Hi Fiona,

Having reviewed the modification and supporting documents, the proposed changes and their origins are well understood. Dealing with an important matter by exception, as the majority of the changes have little impact, the key issue for the City relates to the loss of the lobby, reception area, awning and presumably signage along Pyrmont Street which currently give the building an address and highly sought-after activation. In place of the lobby the Proponent is seeking to give an assurance that a future MOD will be lodged for an “active wall treatment” which may or may not include a combination of light, colour and activity along the frontage.

drawing title
Level 1 Floor Plan

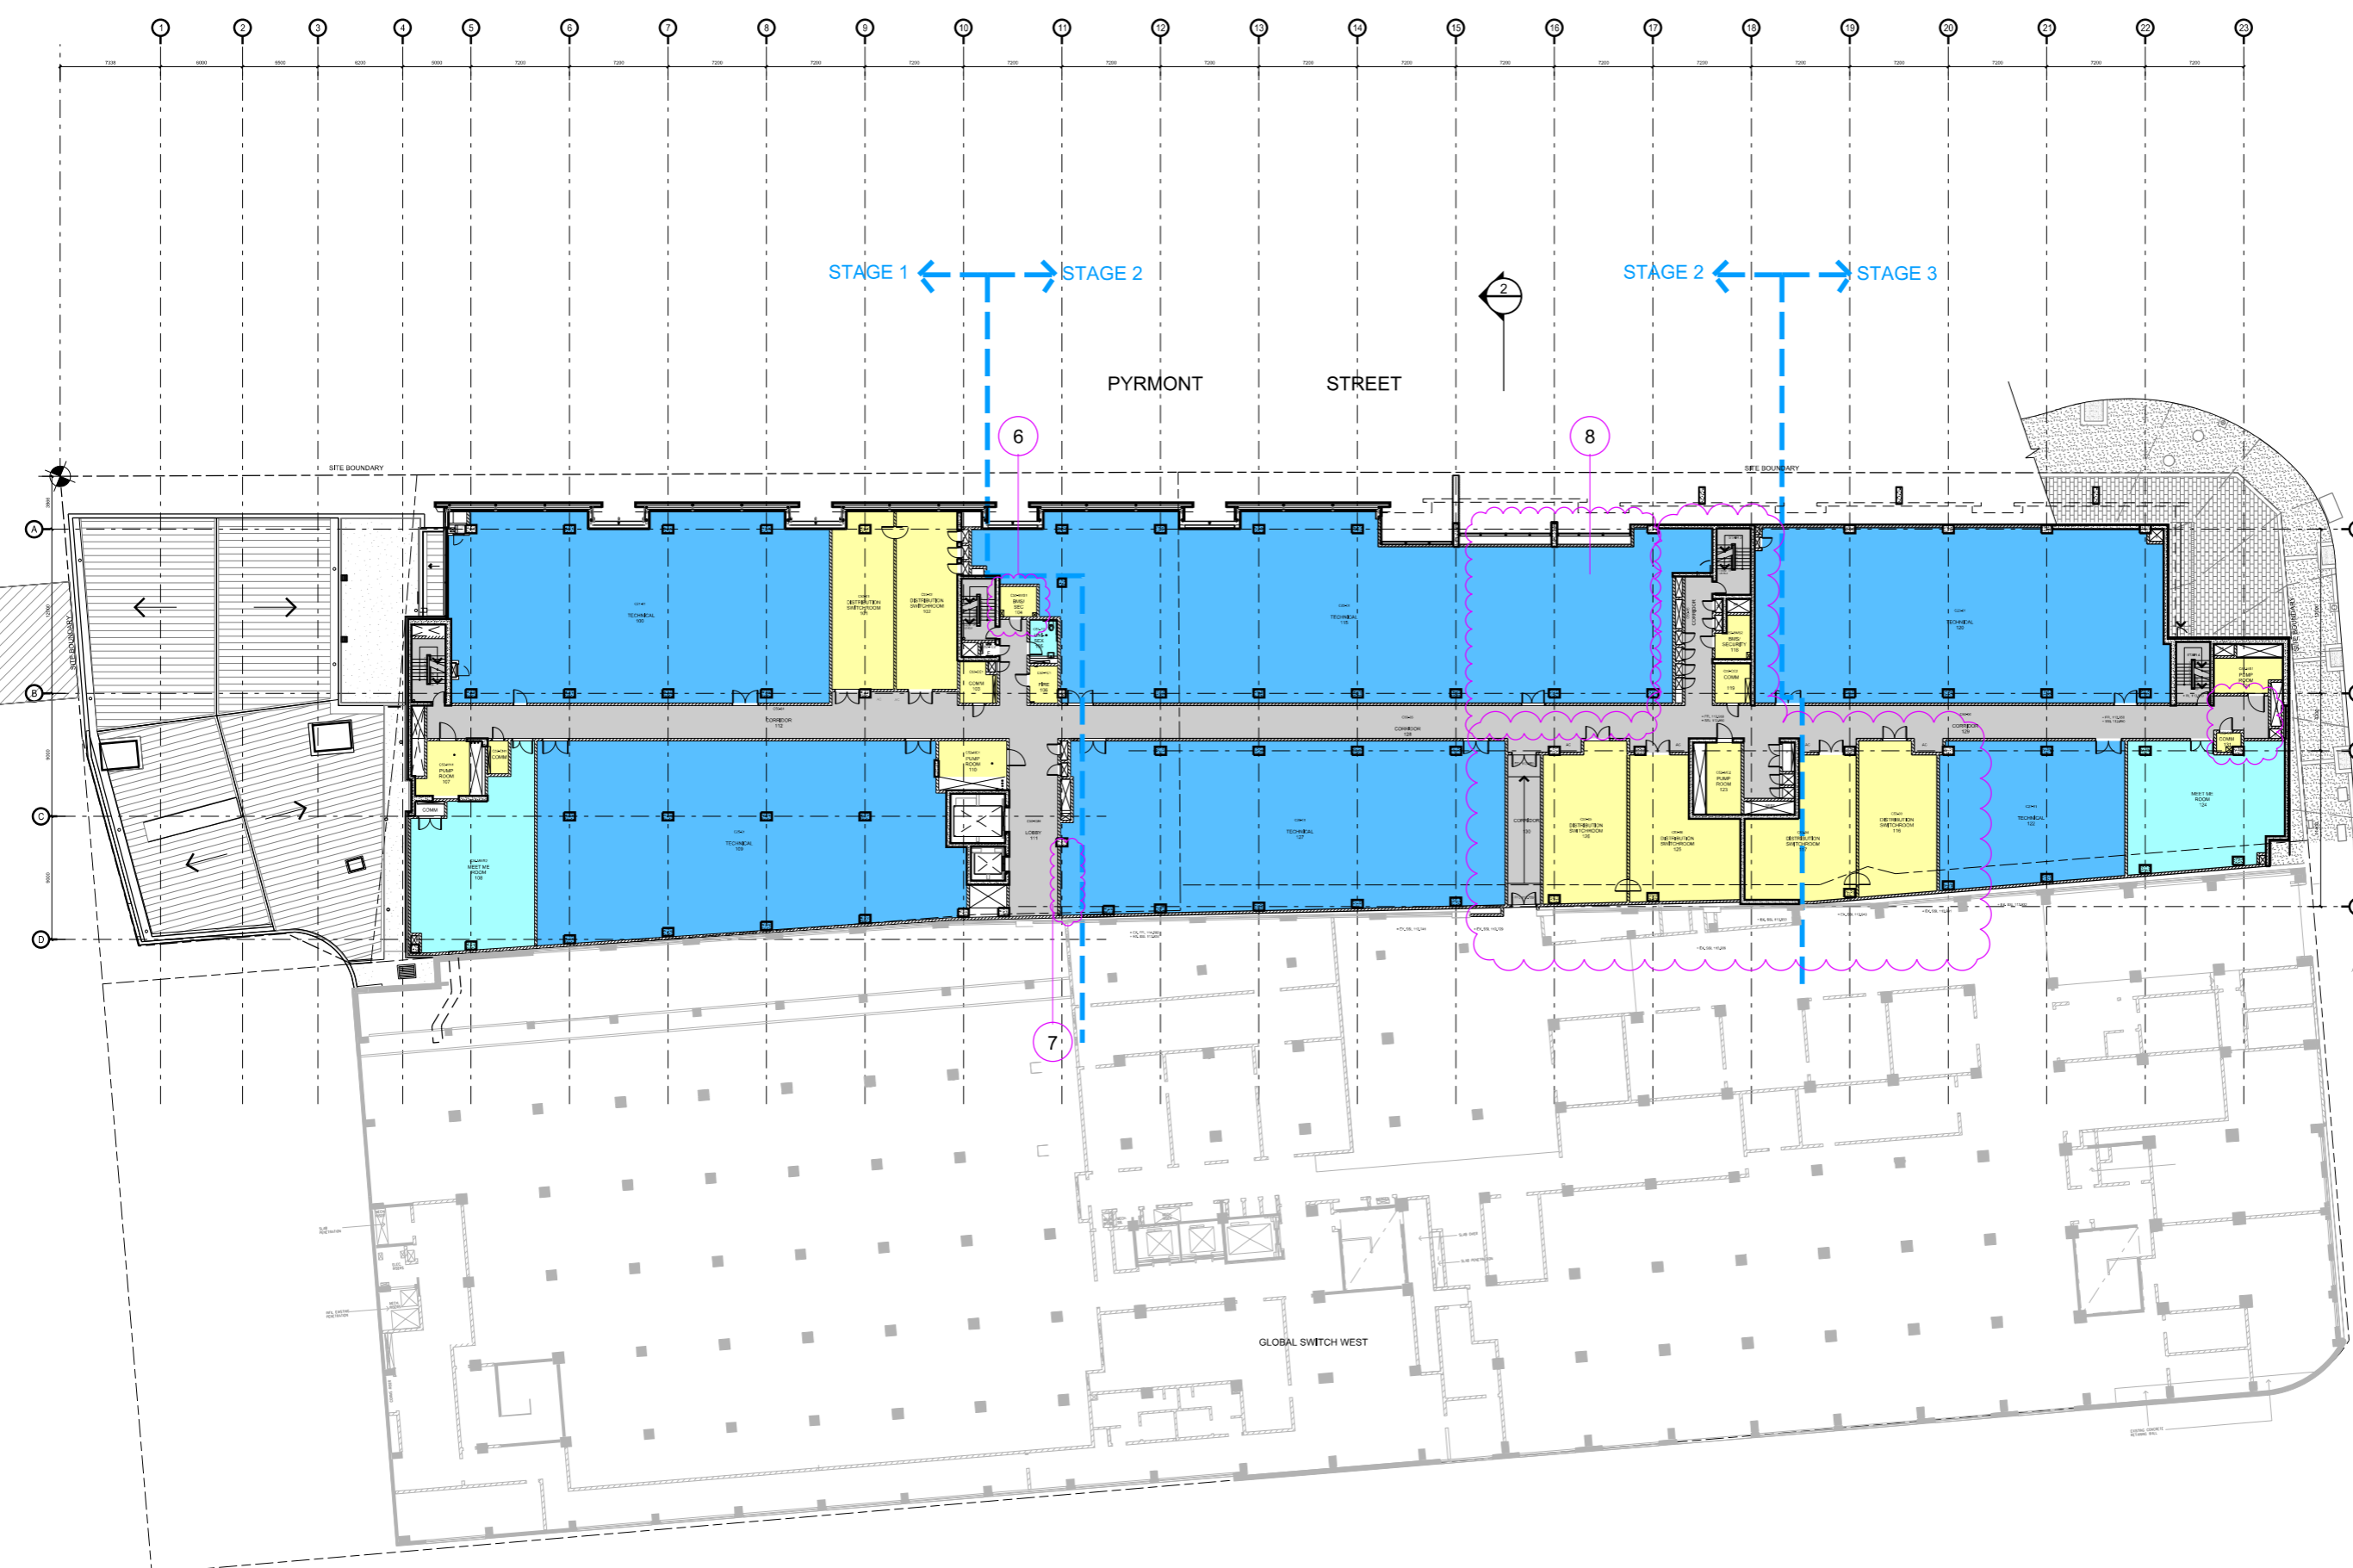
- The approved glazed wall system appears retained despite the presence of solid walls behind it. Opportunities to maintain a glazed and fully transparent frontage should be exhausted. For example, between grid lines 16 and 18 in plan and elevation there is a meeting room with solid walls, beyond which sits the glazed wall system as a second skin. Surely the meeting room can have genuine glazing. Other opportunities may also be relevant in the technical space alongside; and
- The blade wall around the former lobby, protruding into the footpath zone, should not hit the ground if there is no surveillance of the area. The wall should terminate above the first floor level.
